Letter No.02/25851/90, dated 7-6-'91

Sub: MMDA - Planning Permission - Proposed
Construction of Brick Chamber in
S.No.322/1,2A & 329/10 of Kannapalayam
Village - approved - regarding.

3. The approved plans are numbered as C/PP/111A&B/91
sent herewith for further action at your end along with planning
permit No.13412 dated 7-6-'91.

PLAN SHOWING THE TOPO PLAN,
 SITE PLAN & KEY PLAN OF THE
 PROPOSED CONSTRUCTION OF
 BRICK CHAMBER IN SPOS 322/
 322/2A & 329/1D OF
 NO. 7. KANNAPALAYAM VILLAGE
 SRIPERUMBADUR TALUK
 CHENGAI ANNA DISTRICT.

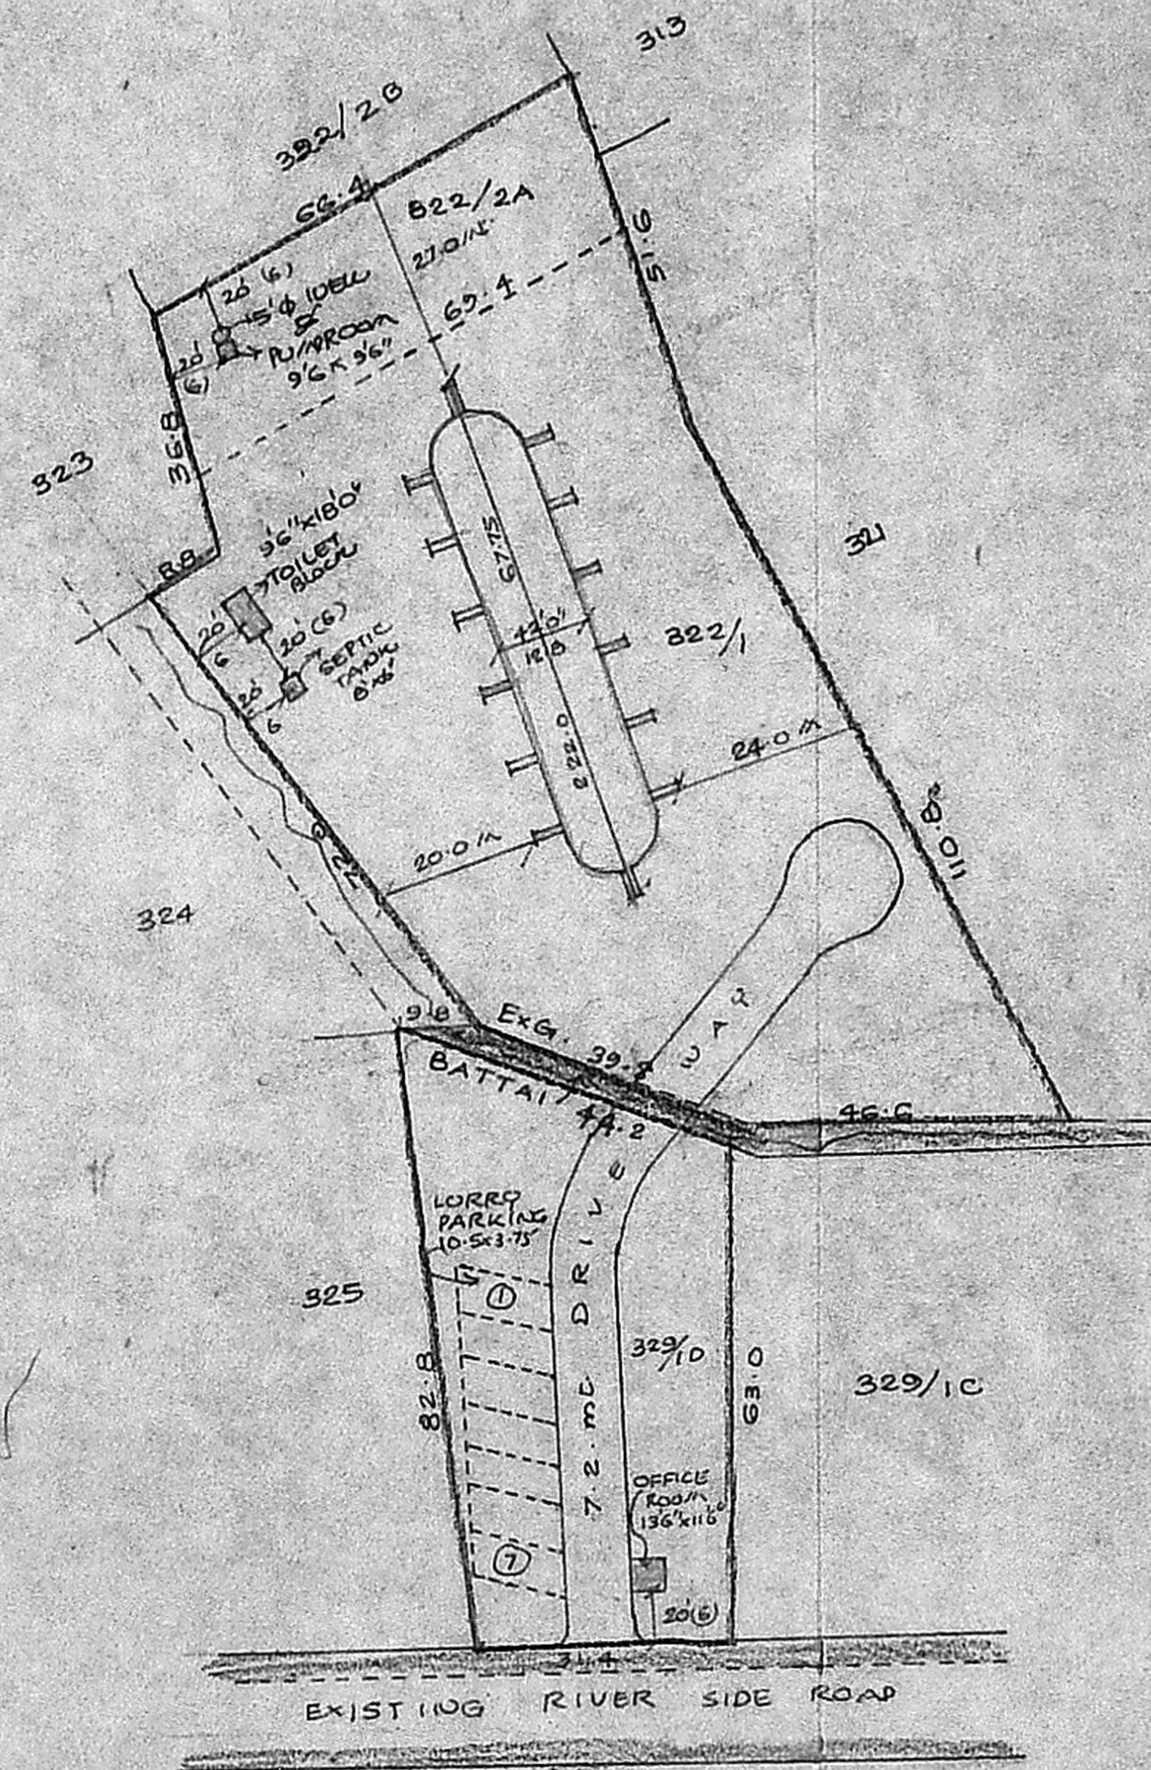
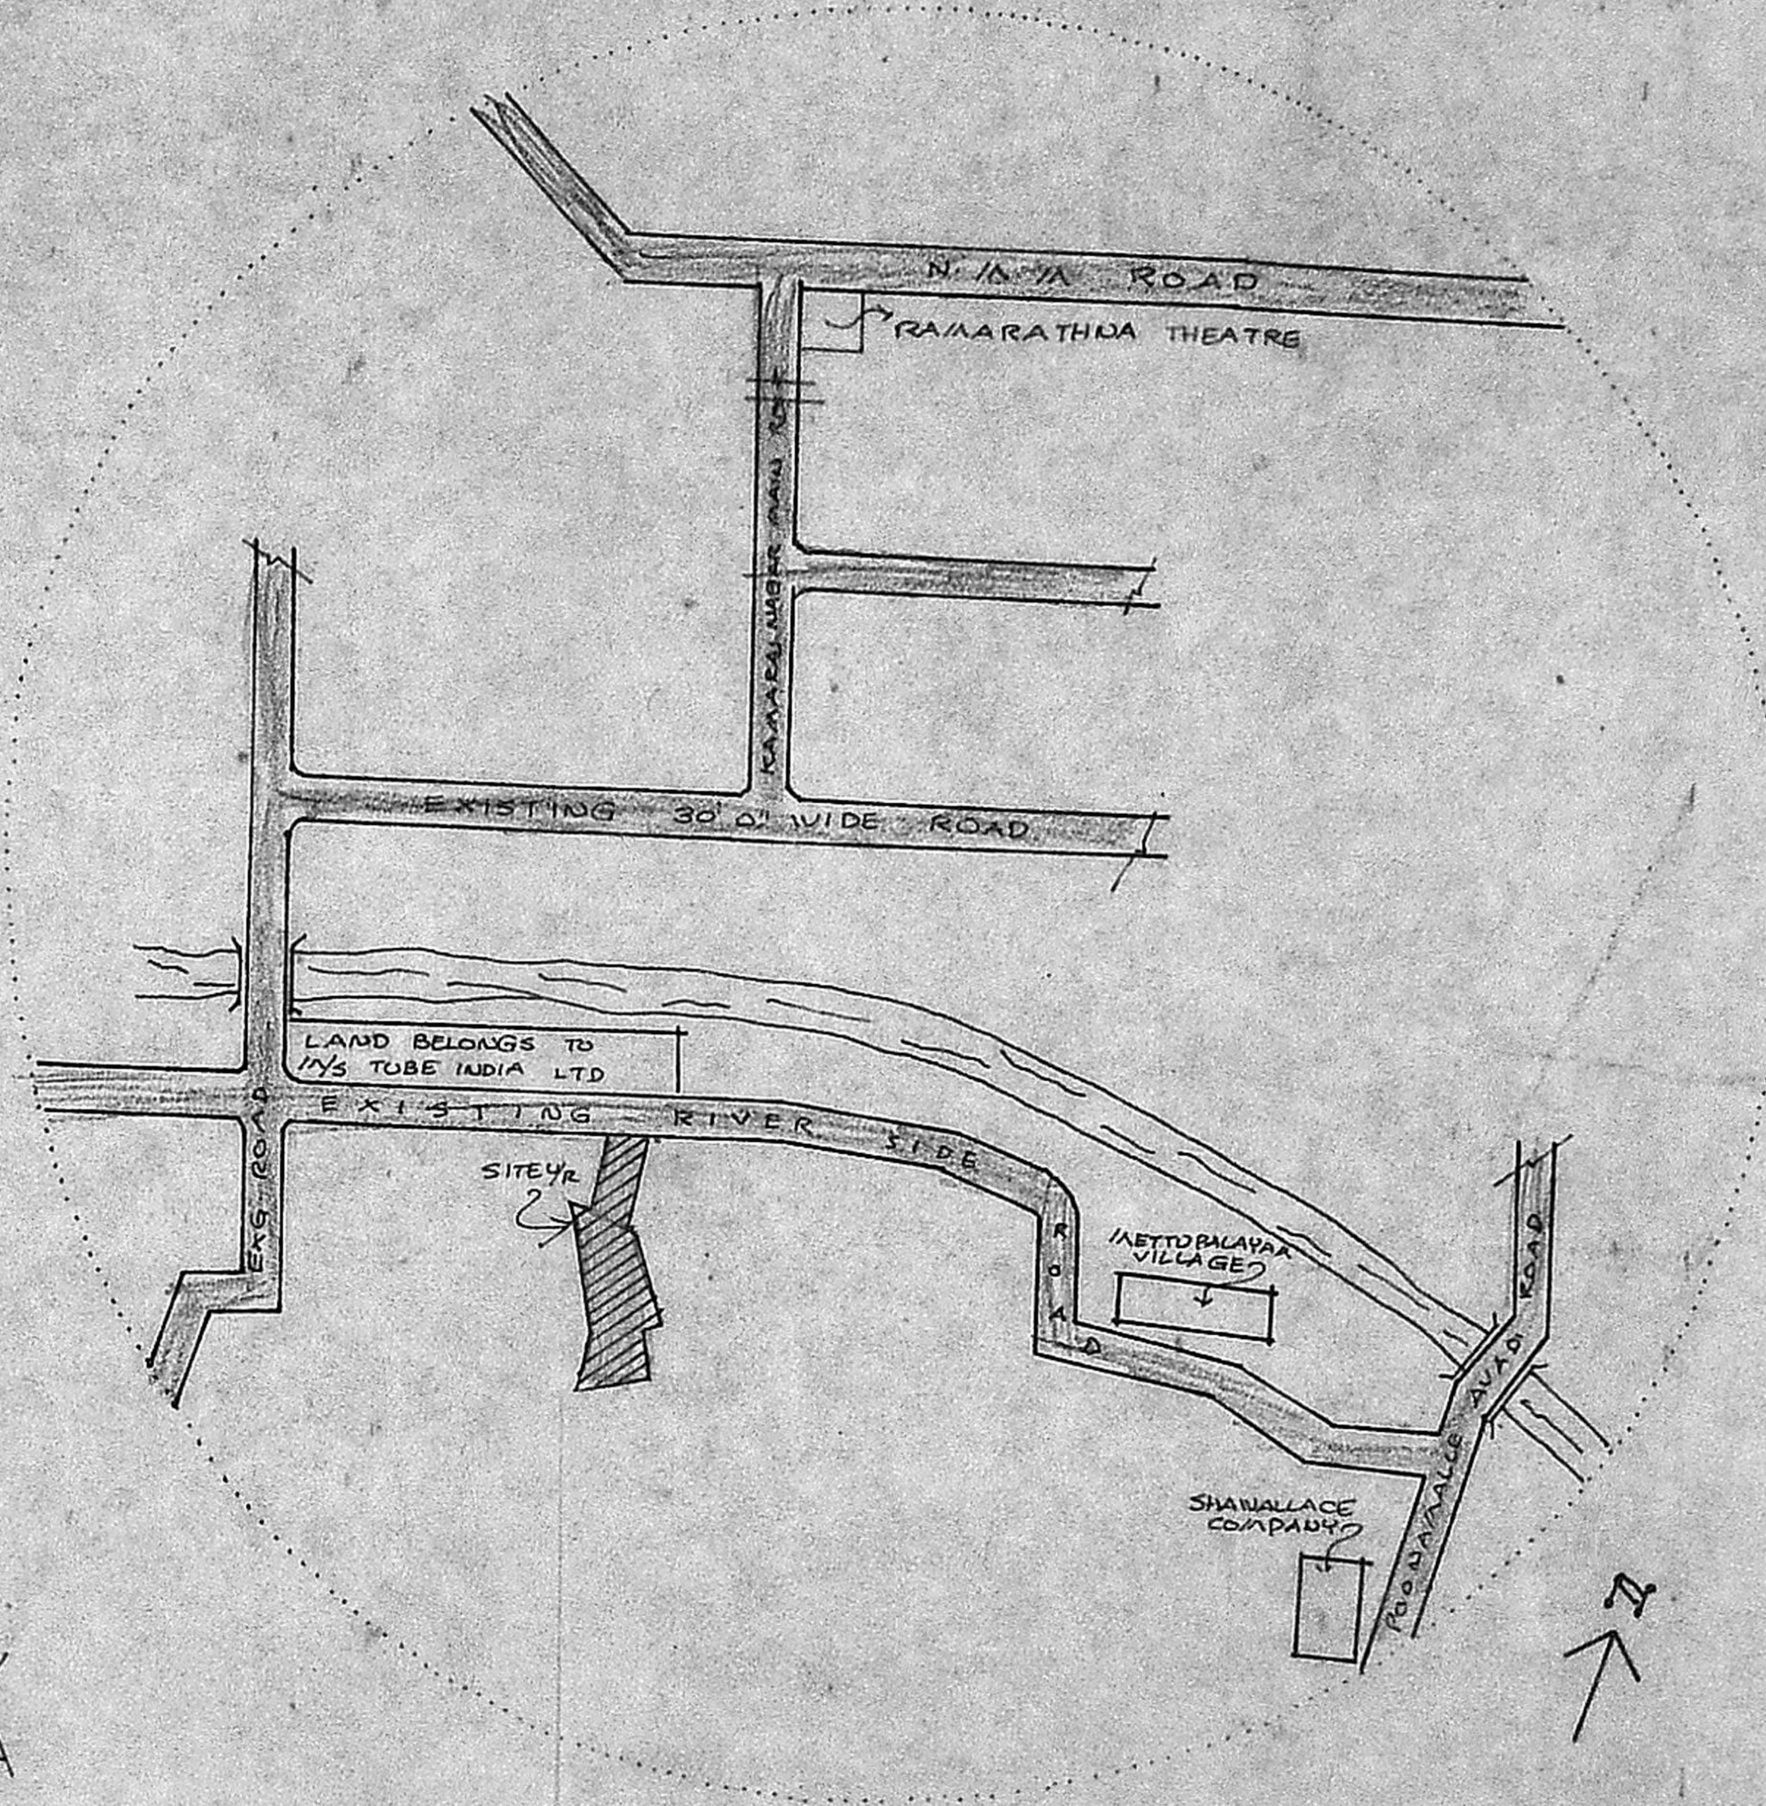
The proposal received in the reference cited for the
construction of brick chamber in S.No.322/1, 2A and 329/10 of
Kannapalayam village has been examined and found approvable
subject to condition that a suitable culvert has to be provided
to cross over the Batkai.
